Statement of Response to An Bord Pleanála's Notice of Pre-Application Consultation Opinion

Strategic Housing
Development at Rosshill,
Galway

Document Title: **Statement of Response to An Bord Pleanála's Notice of Pre-Application Consultation Opinion**

# Car Park Drainage Swales Detail

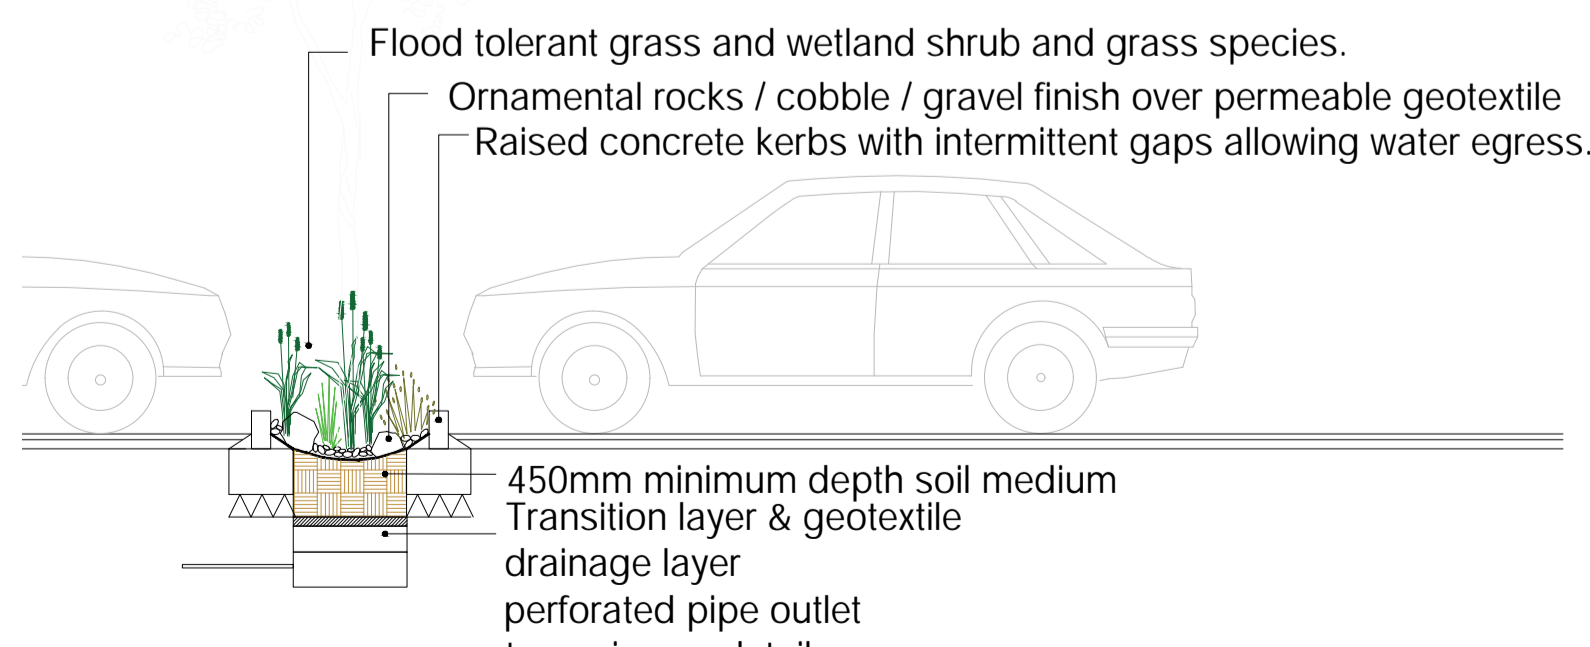
- a) *Provide further justification in relation to the location of the carpark adjoining the rear of the apartment building, the absence of any designated communal open space and the residential amenity of those future occupants of the ground floor units.*

Locating car parking here also brings activity and vibrancy to the ‘hub’ of the proposed development, with the retail/commercial and creche nearby. The car parking has been designed, following advice from the City Council’s Recreation and Amenity Department, to incorporate swales which visually break up the parking and softens the area. It is held this creates a more welcoming space within the wider development and indeed for the residents of the apartment building itself. Proposed swale detail is set out in the landscaping information which accompanies the application, and specifically in CSR drawing 19112-4-101 an extract of which is shown below.

In summary, the car parking provided to the apartment building is considered to serve the residents in terms of needs, while balancing this with the aim of creating a visually pleasing space not dominated by car parking itself. The use of swales and the landscape buffering adds visual interest.

Drawing file: ONOM / 20175 -3206 Apartment Building & Commercial__Roof Plan & Section.pdf

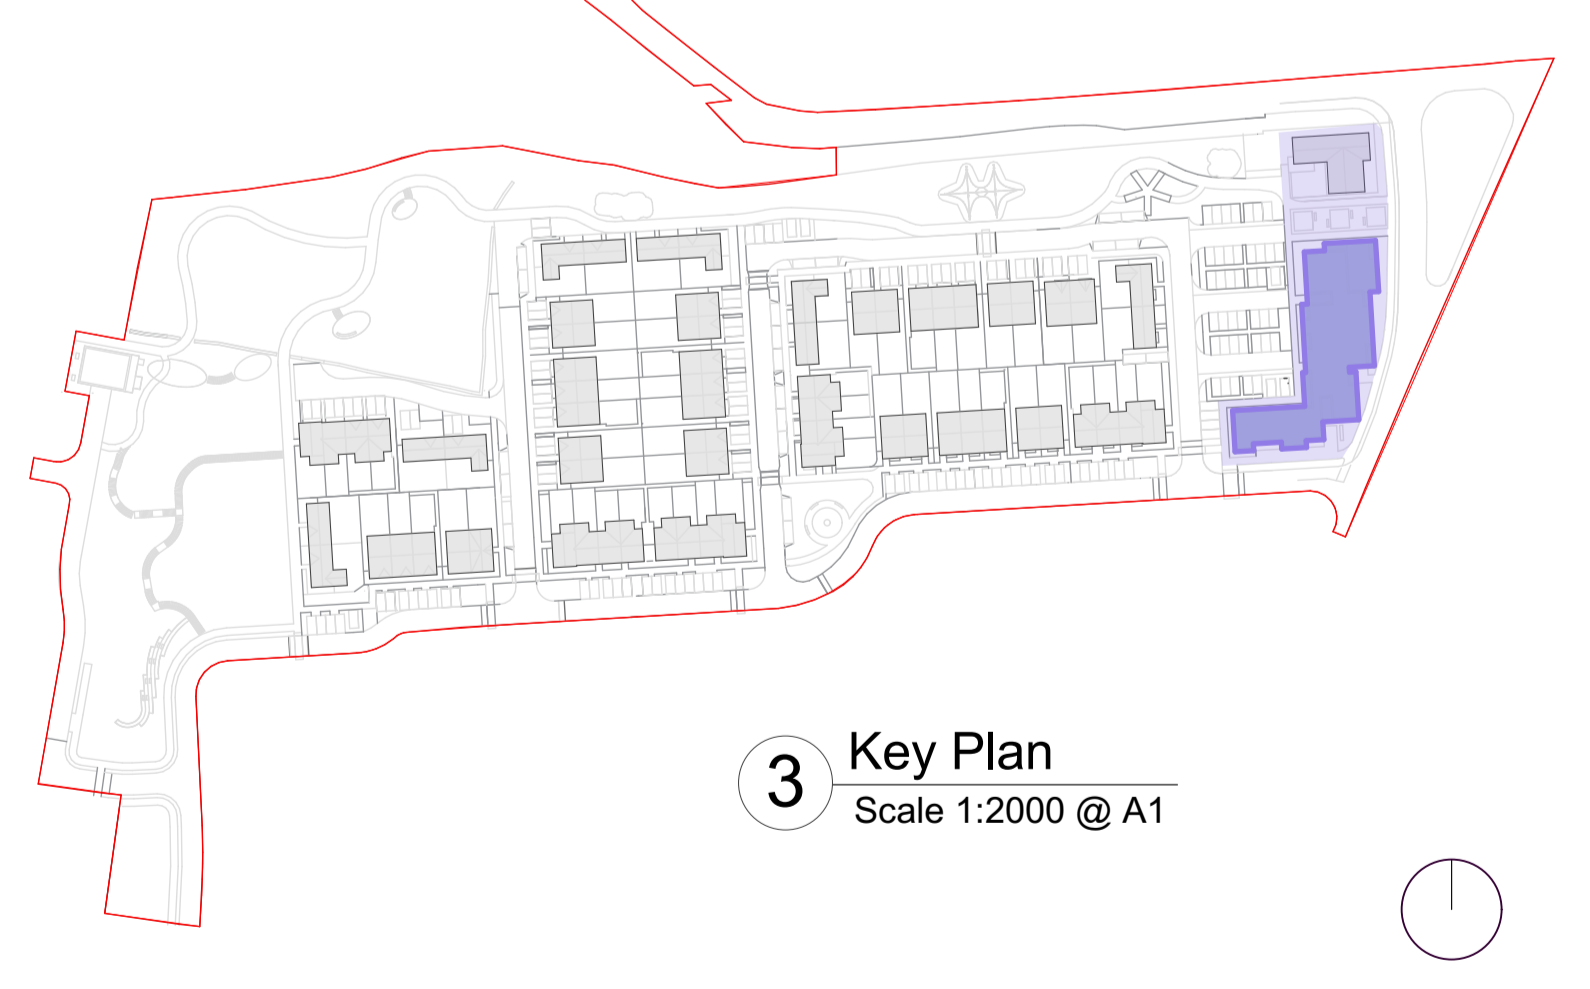
At the Stage 2 tripartite meeting the discussion around the matter of open space related in the main to the southern section of the apartment building which includes the retail/commercial element at ground floor level. It was noted that communal open spaces should be provided to the apartment building and this should be independent of the 15% overall public open space. Amenity of ground floor units was also discussed.

The apartment building therefore has a dedicated, secure communal space which is accessed via a secure internal stairs and lift.

Title: **Typical Pumping Station Details**

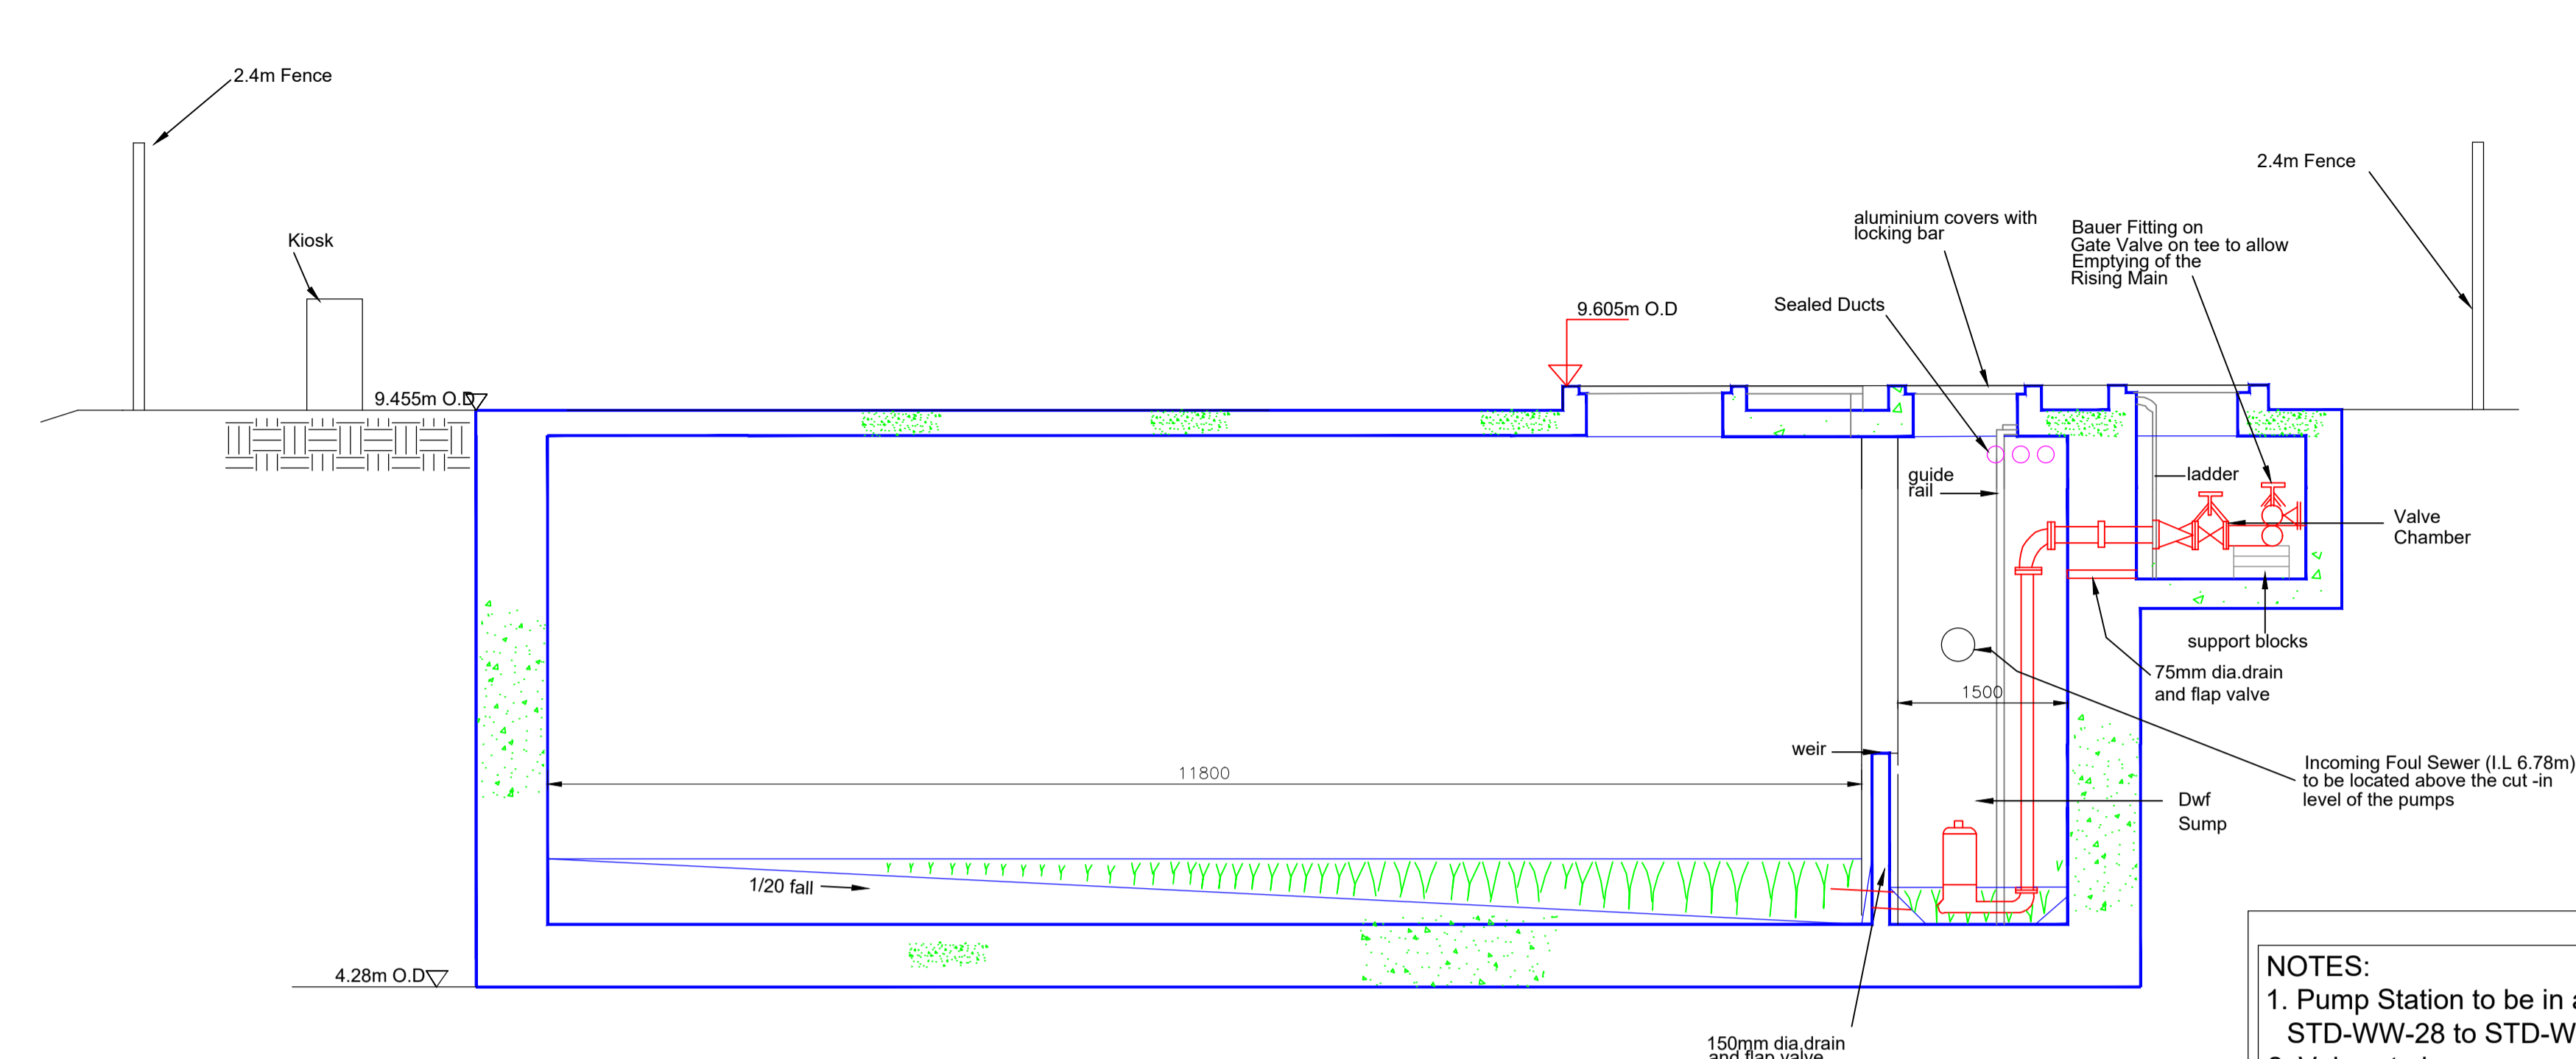
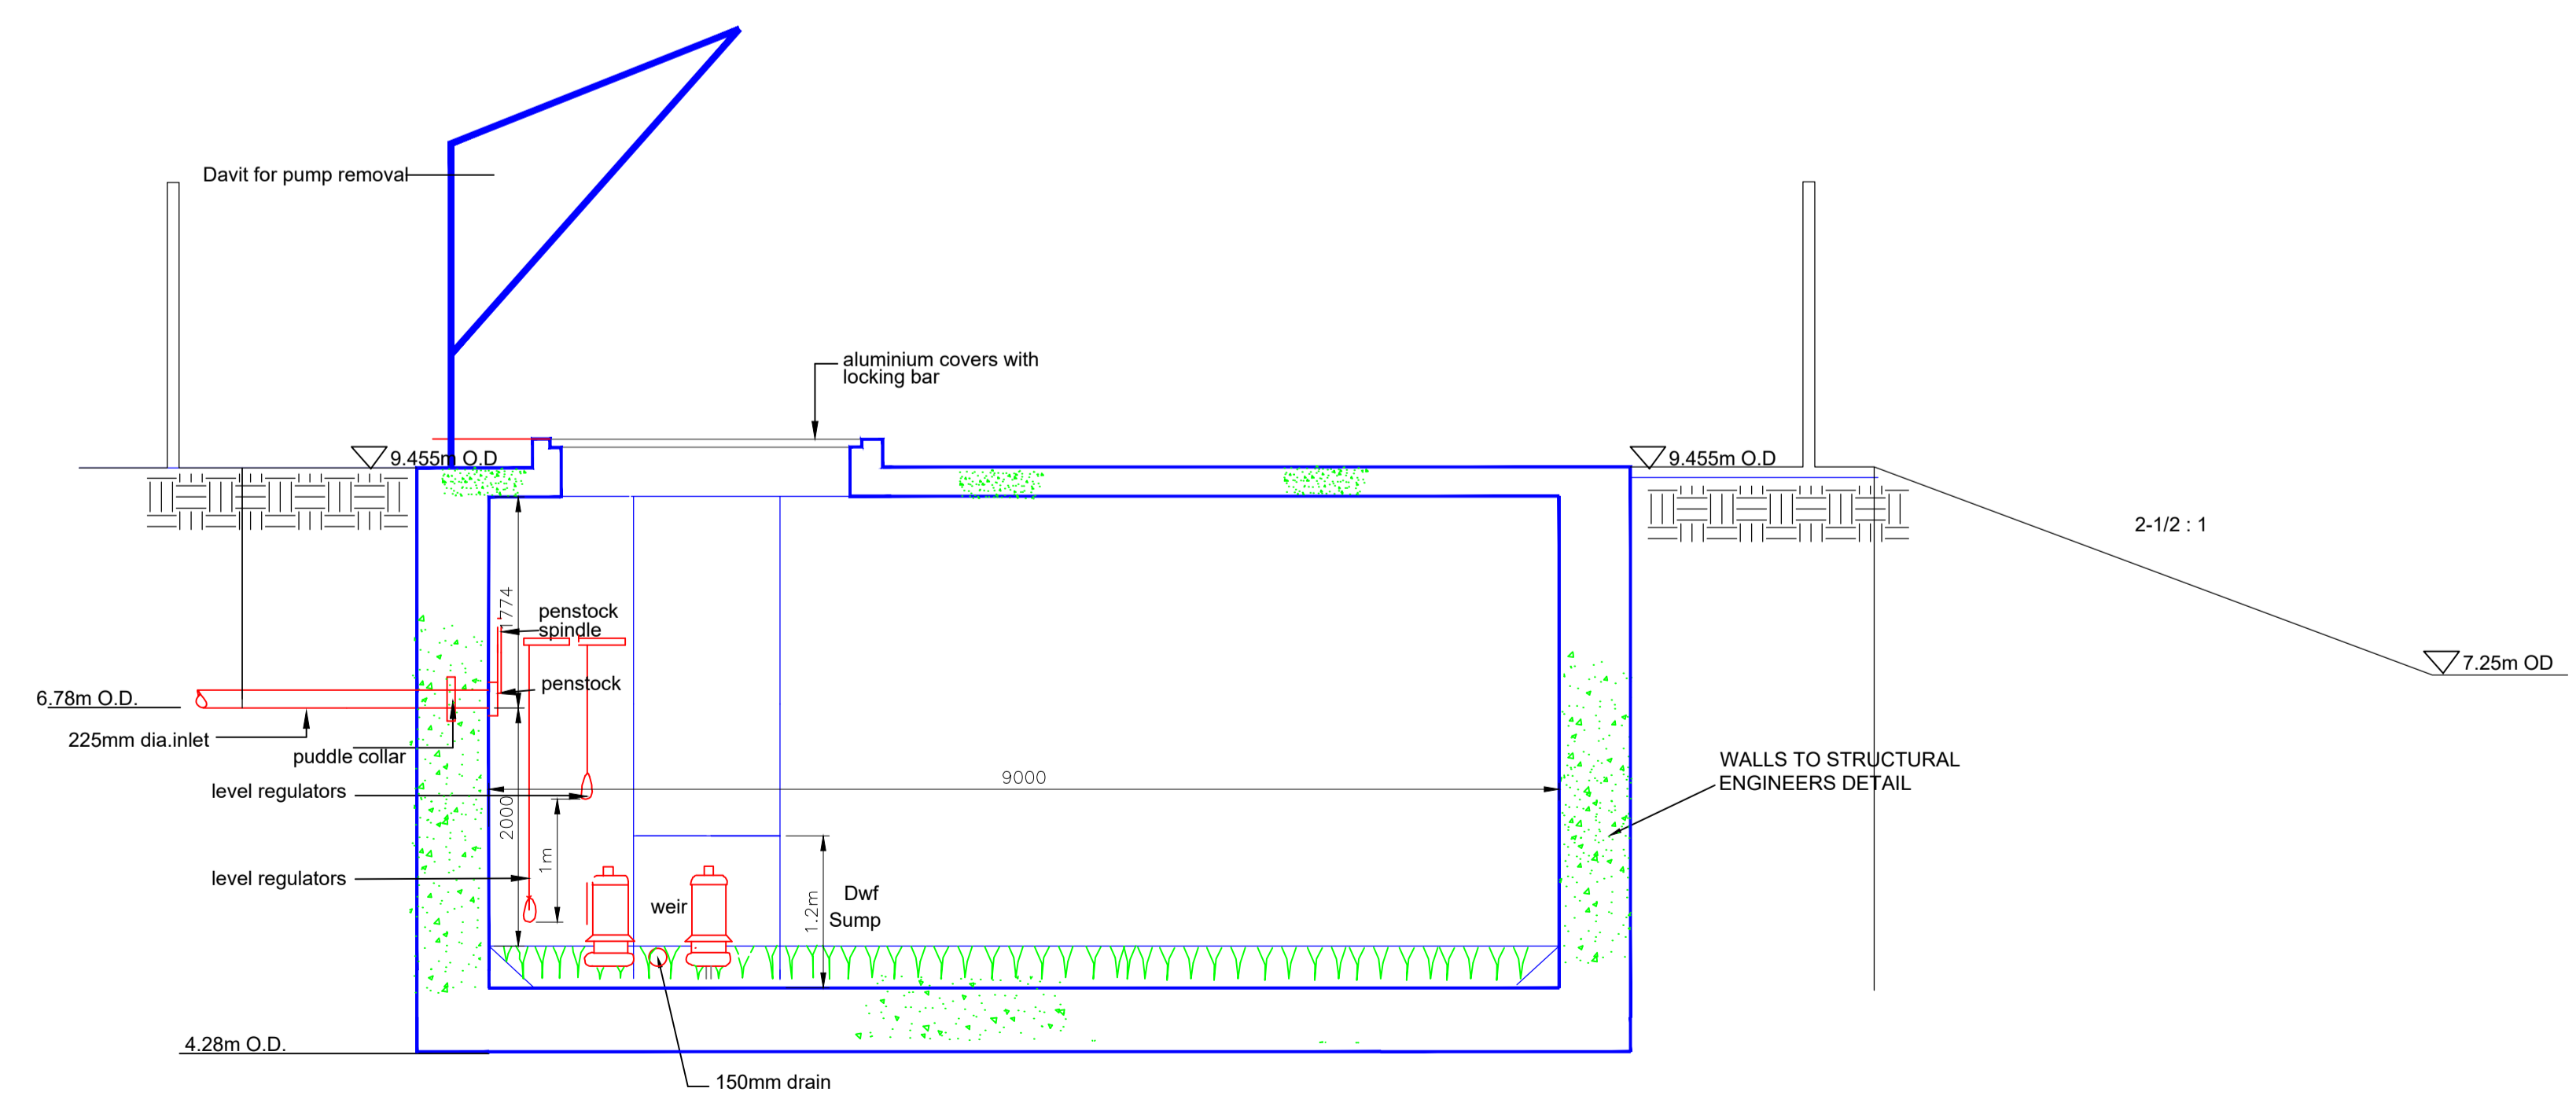
- c) *Provide further justification in relation to location of the pumping station. This further justification should address, inter alia, the options considered which would minimise any ecological impact on the site and the surrounding area.*

During discussions at the tripartite meeting both the Inspector and members of the Council considered this positioning could be reconsidered with a view to maintaining trees where feasible and preserve the character of the site. It is acknowledged that a Development Plan objective of the site is to “*have regard to the sylvan character of the site...*”.

The pumping station design is mainly underground and does not require a surrounding fence so will not be overly intrusive. Tobin drawing 10690-2116 rev P03 illustrates this clearly – an extract is shown below for ease.

The revised location avoids the tree group entirely and stone wall, while still achieving the necessary gradients for engineering requirements. The pumping station as proposed will take wastewater via a rising main to discharge to the existing Irish Water (IW) pumping station located at Merlin Park.

Taken together, it is held that the revised location of the pumping station achieves the best design response from an engineering, landscape and ecological stance. Its largely underground elements also mean it will not be viewed as a visually intrusive structure from users within the proposed amenity space.
